Your Ref
EG/45/14/PL
Our Ref
PLAN-006989
Date
11/08/2014

Proposal: Hardstanding for proposed car-park together with air conditioning unit/enclosure, handrail & external lighting.
Site: 17 Elm Grove South, Barnham, PO22 0EJ.
EG/45/14/PL

| TITLE<br>SITE PLAN WITH DRAINAGE                                                    |                                                                               |

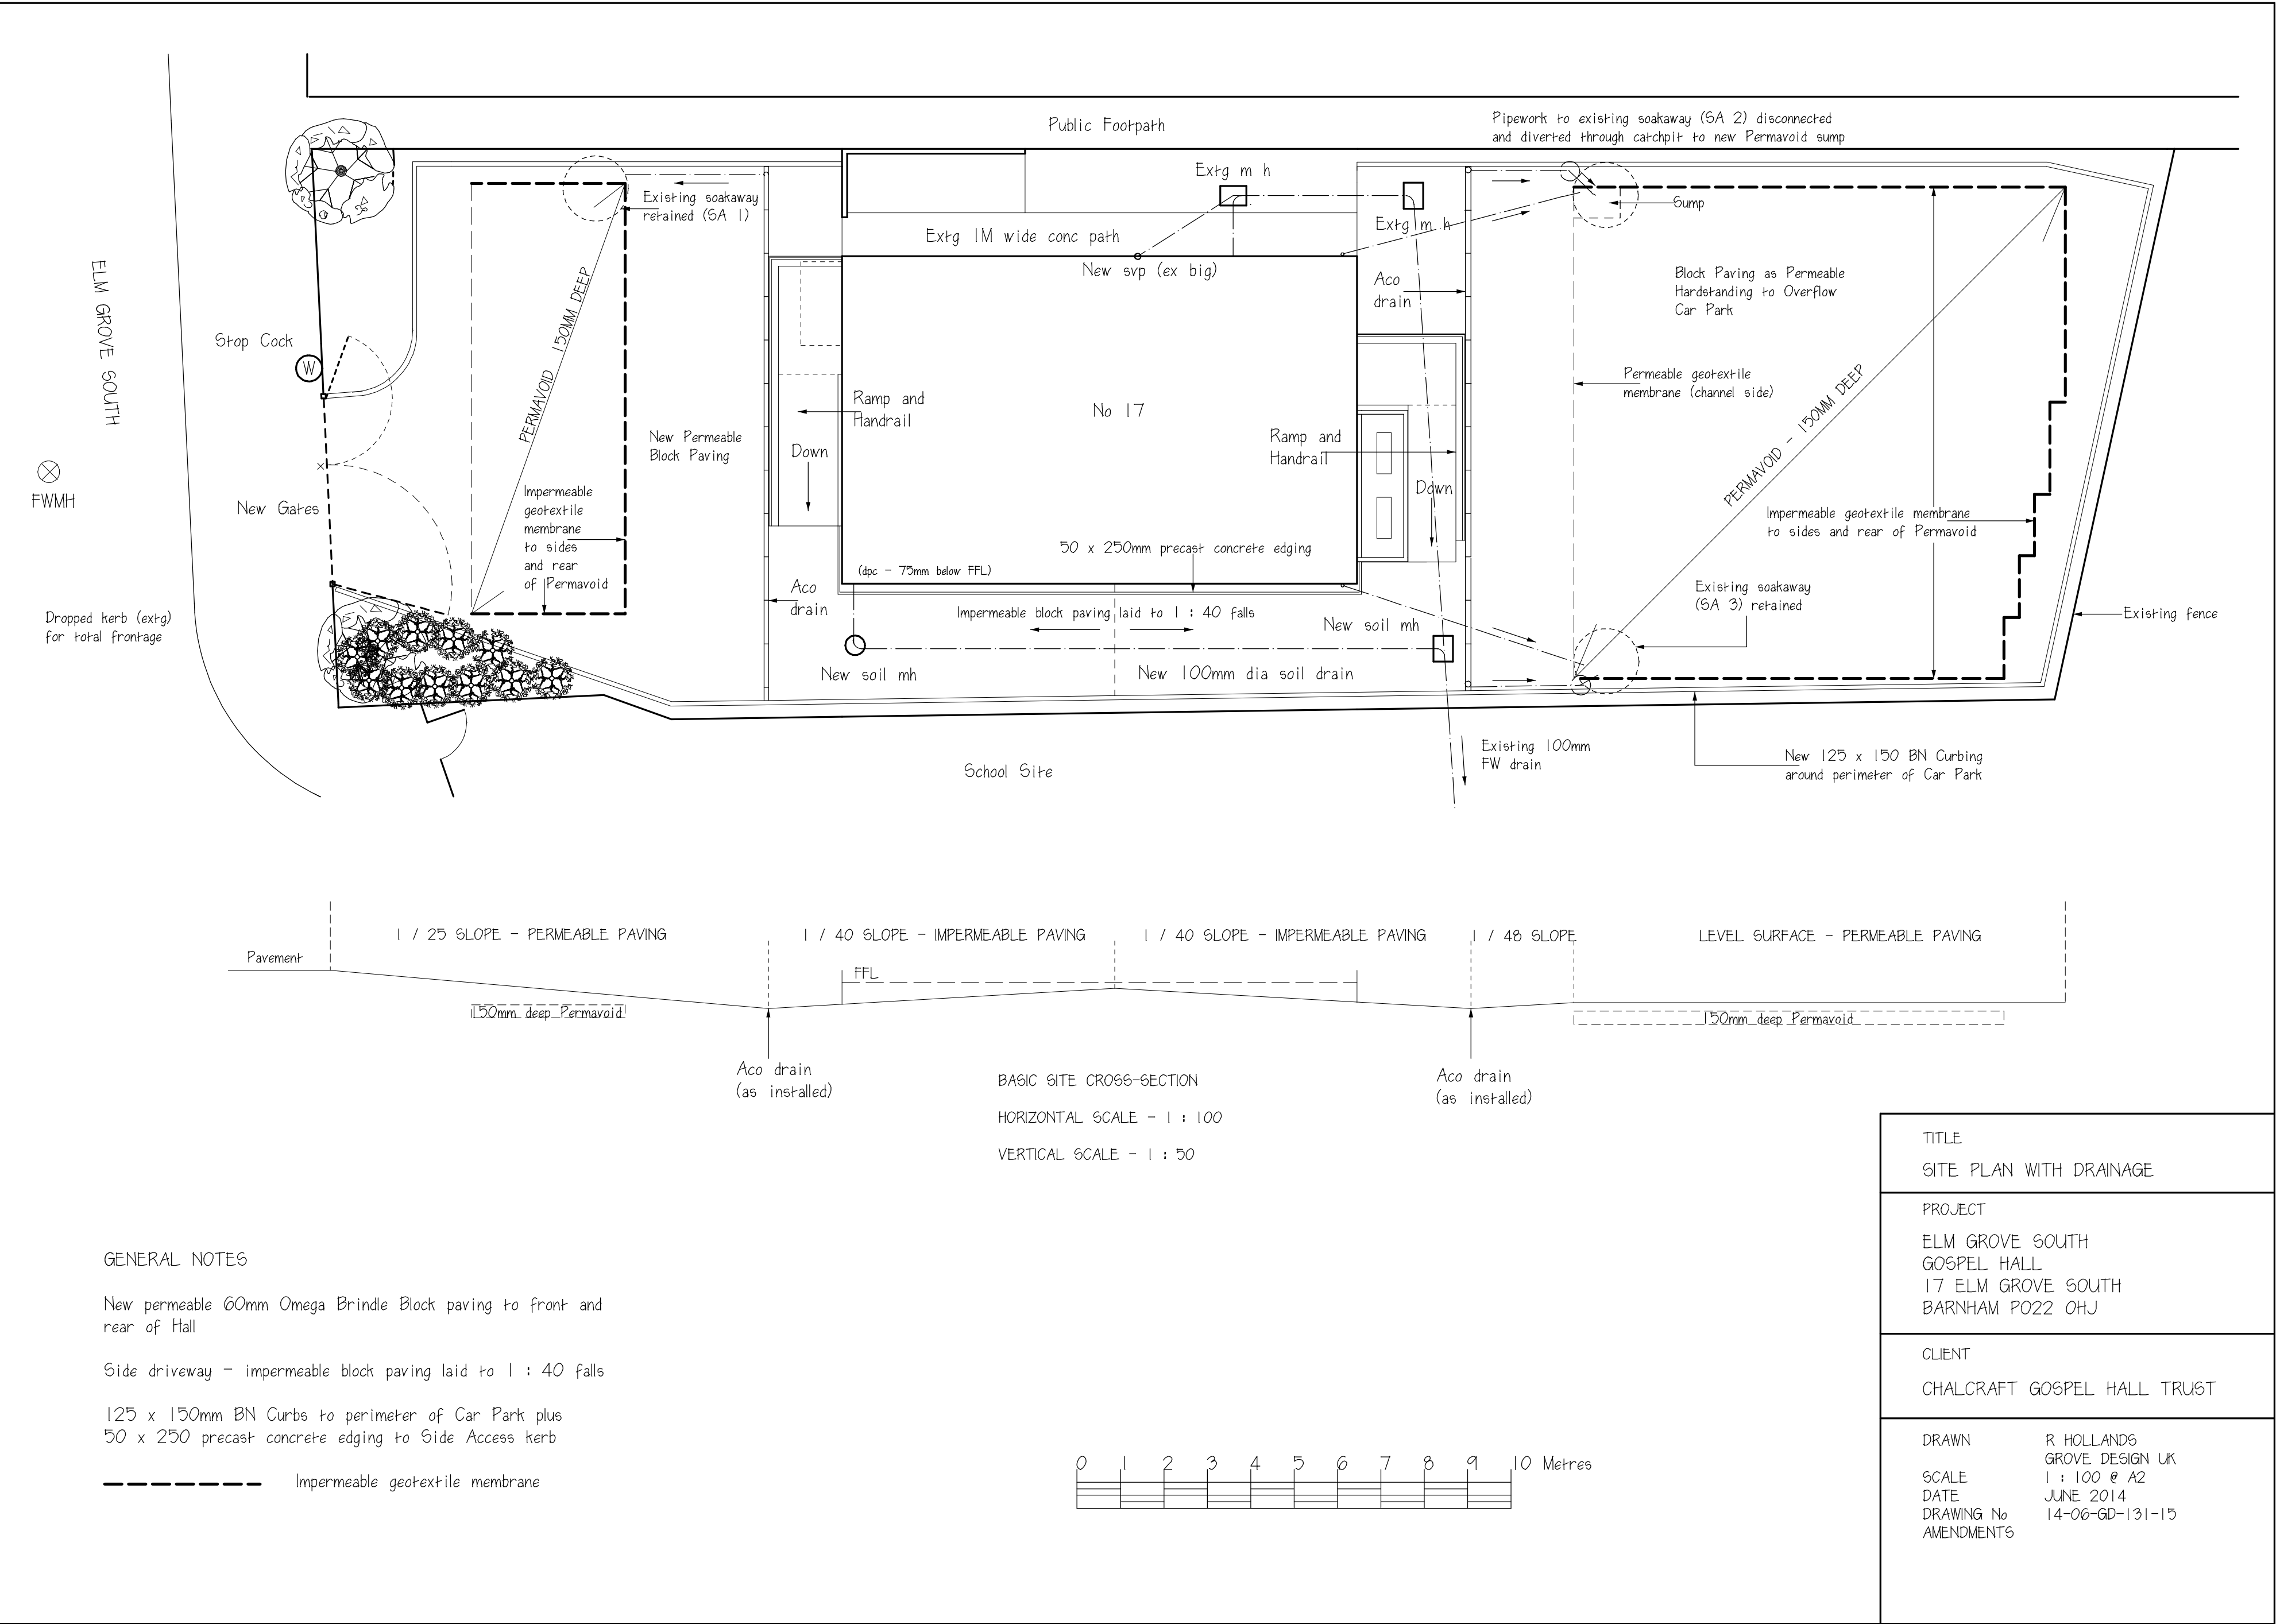
Our initial investigations indicate that there are no public surface water sewers in the immediate vicinity to serve this development. Alternative means of draining surface water from this development are required. This should not involve disposal to a public foul sewer.

The Council's Building Control officers or technical staff should be asked to comment on the adequacy of soakaways to dispose of surface water from the proposed development.

The planning application form makes reference to drainage using Sustainable Urban Drainage Systems (SUDS).

Under current legislation and guidance SUDS rely upon facilities which are not adoptable by sewerage undertakers. Therefore, the applicant will need to ensure that arrangements exist for the long term maintenance of the SUDS facilities. It is critical that the effectiveness of these systems is maintained in perpetuity. Good management will avoid flooding from the proposed surface water system, which may result in the inundation of the foul sewerage system.

Thus, where a SUDS scheme is to be implemented, the drainage details submitted to the Local Planning Authority should:

- Specify the responsibilities of each party for the implementation of the SUDS scheme

- Specify a timetable for implementation

- Provide a management and maintenance plan for the lifetime of the development. This should include the arrangements for adoption by any public authority or statutory undertaker and any other arrangements to secure the operation of the scheme throughout its lifetime.

Land uses such as general hardstanding that may be subject to oil/petrol spillages should be drained by means of oil trap gullies or petrol/oil interceptors.
